Recommendation Report for Planning Permission for Works or Extension to a Dwelling

REF NO: P/77/22/HH

LOCATION: 15 Lagoon Road
Pagham
PO21 4TJ

PROPOSAL: Erection of single storey front porch and rear extension with steps and new roof covering.

PROPOSED ELEVATIONS

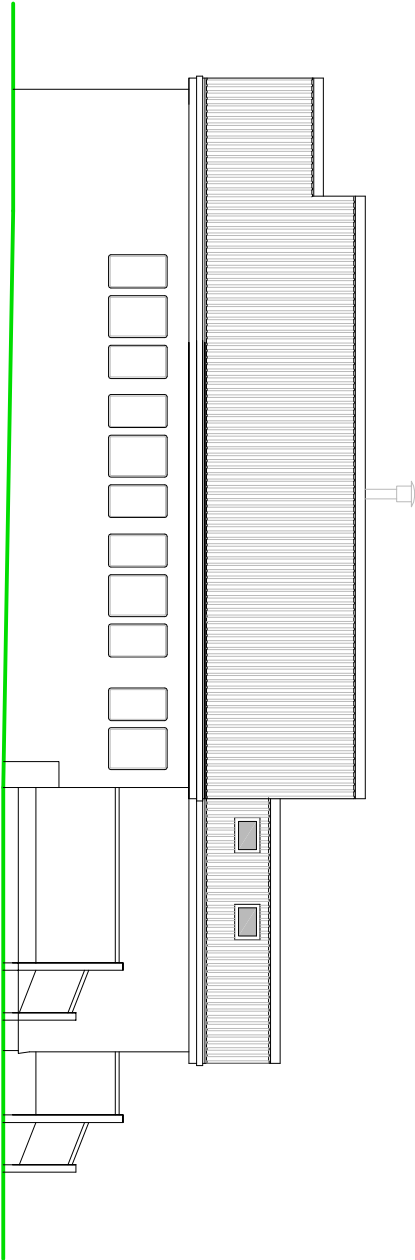
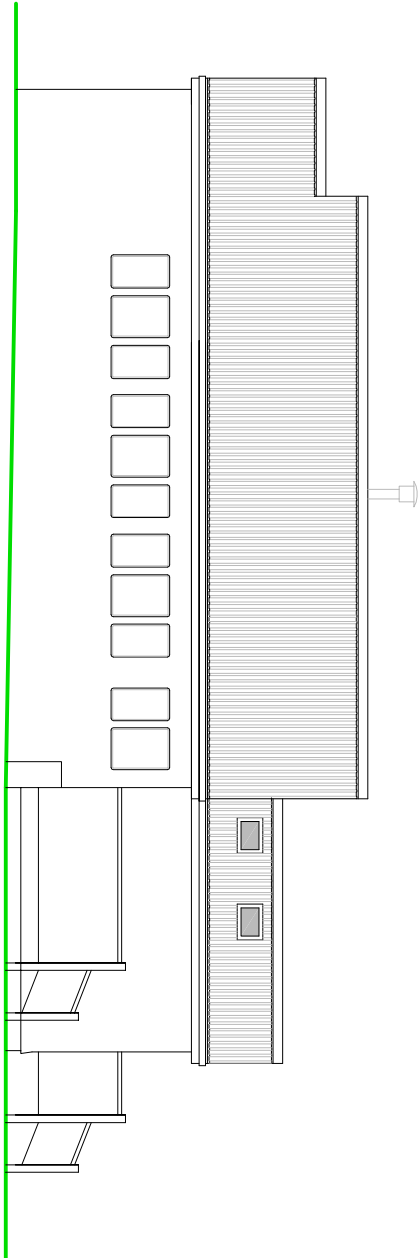
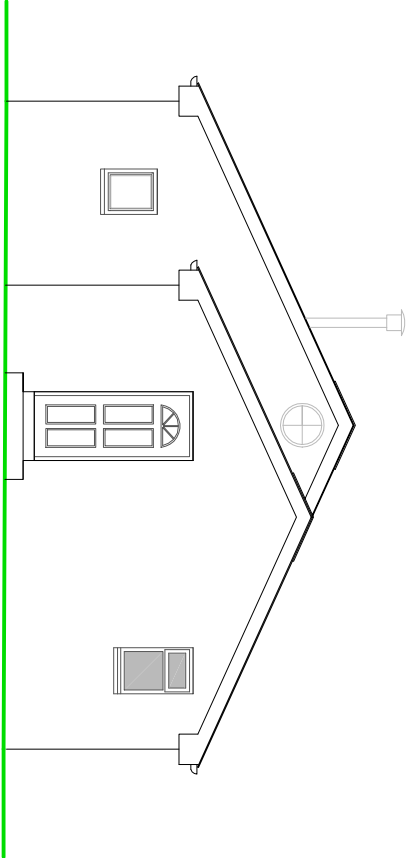
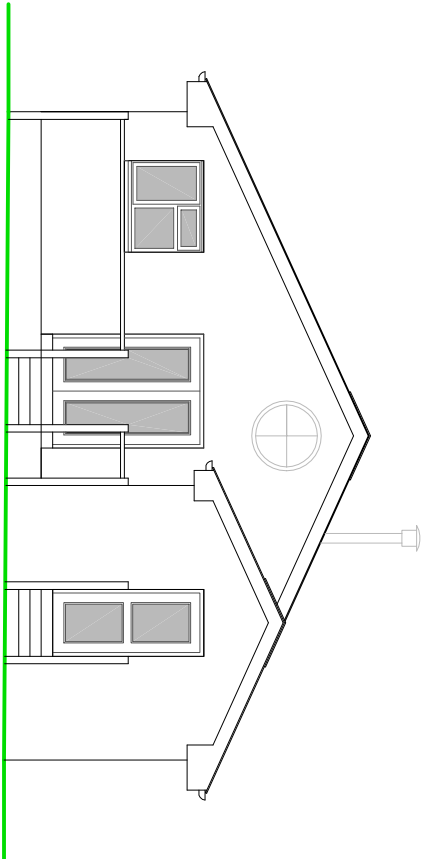
The development includes works to the front and rear extensions and a replacement roof of the property, and will be visible from the wider area. The materials proposed are in keeping with the existing property and the character of the surrounding area. No colours for the render and new roof have been confirmed, in order to ensure appropriate development a condition will be imposed to require details to be confirmed prior to commencement.

The proposed roofing system shows no details of colour but there are other examples of non-traditional roofing in the area and therefore an additional example will not cause harm to the character of the area.

- 3 No development above damp proof course (DPC) level shall take place unless and until a schedule of colours to be used for external walls and roofs of the proposed extension and replacement roof have been submitted to and approved by the Local Planning Authority and the materials so approved shall be used in the construction of the building/extension.
